Recommendation Report for Planning Permission for Works or Extension to a Dwelling

REF NO: AW/102/18/HH

LOCATION: 18 The Fairway
Aldwick
PO21 4ES

PROPOSAL: Single storey front & side extensions (resubmission following AW/264/17/HH). This application affects the character & appearance of the Aldwick Bay Conservation Area.

NEW GROUND FLOOR PLAN

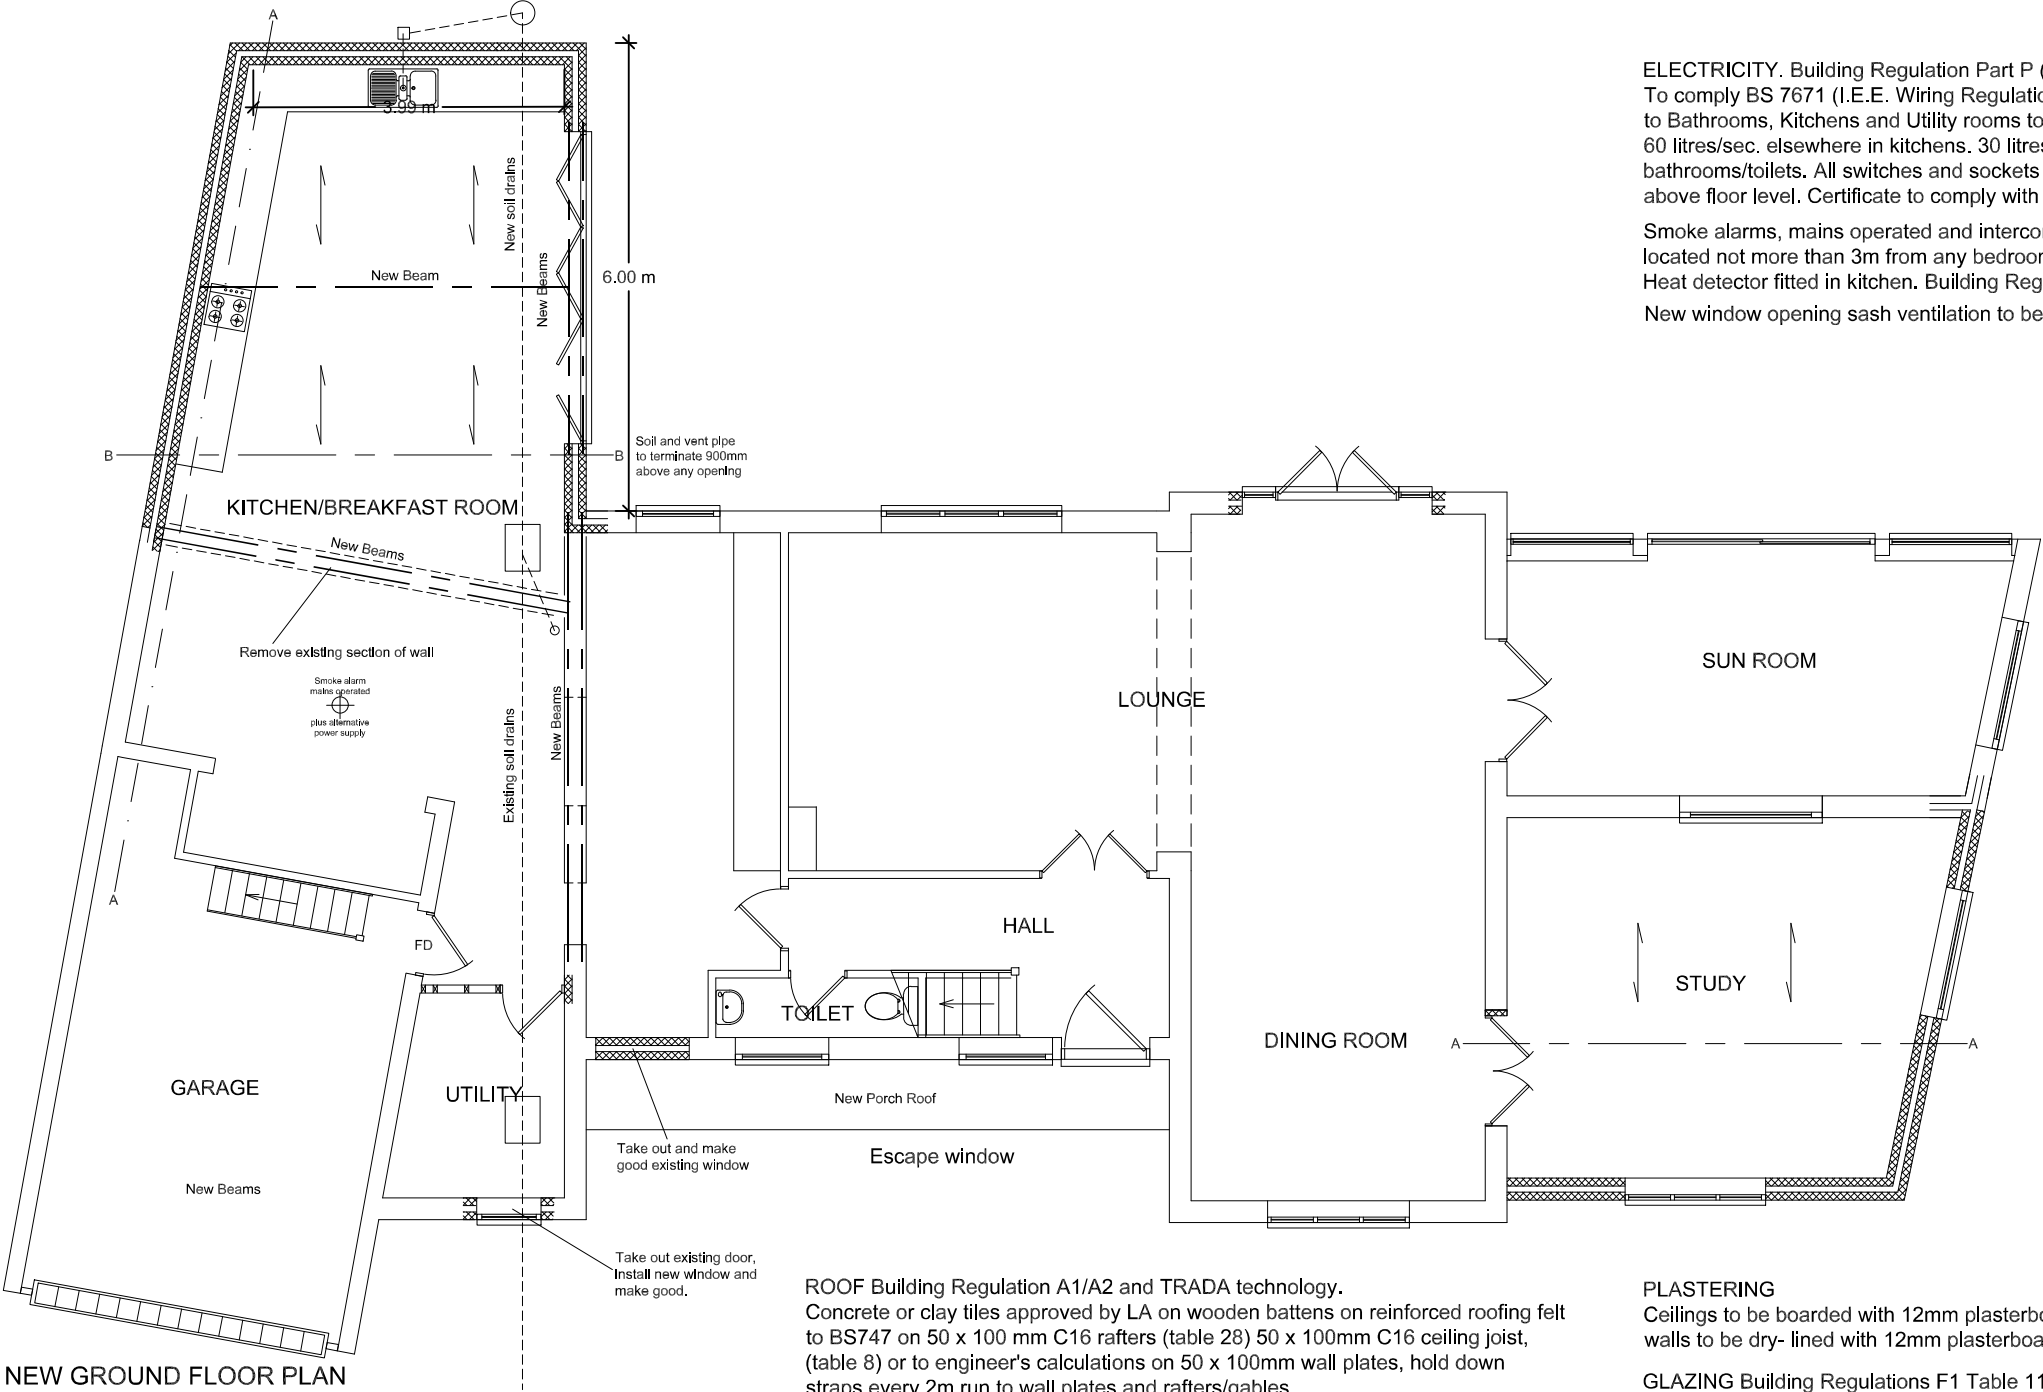
Officers note that the proposed single story side extension would be sited in a particularly prominent position that would be visible from the highway and ultimately the Conservation Area. Additionally the side extension would be sited such that it would abut the existing flat roofed side extension. Therefore when the proposed and existing side extensions are considered together they would have the effect of forming a considerably large side projecting element which would be visible from within the Conservation Area. The application proposes also dummy pitched roof with flat roof (crown pitched roof) with pan tiles atop. While this is not a feature of the host dwelling the roof form is featured on the 2 storey side extension at 19 The Fairway, albeit with thatching rather than pantiles. However, it is considered that the proposed side extension would be of an appropriate size and scale that would not have a detrimental impact on the character of the host dwelling or the conservation area.

Currently the dwelling enjoys a balcony area to the side of the property abutting Bay Walk. The balcony area is above the existing flat roofed extension. From a search of the planning history no permission for the side existing side extension and balcony can be found. However from an assessment of the plans it is noted that the existing balcony area balustrading is to be moved marginally onto the flat roof of the new side extension as necessitated by the proposed dummy pitched roof that is proposed. It is

considered that balconies in such a visible position within the Conservation Area would have a detrimental impact upon it. Given that the balcony area would not be extended significantly onto the flat roof of the proposed side extension, would be roughly the same size as existing and would be afforded screening by the proposed dummy pitched roof, it is considered that it would not have a detrimental impact on the Aldwick Bay Conservation Area. A condition restricting the balcony to the area shown on the submitted plans would be imposed on any grant of planning permission:

The roof area of the extension hereby permitted shall not be used as a balcony, roof garden or similar amenity area, except as shown on the approved plans, without the grant of further specific permission from the Local Planning Authority.
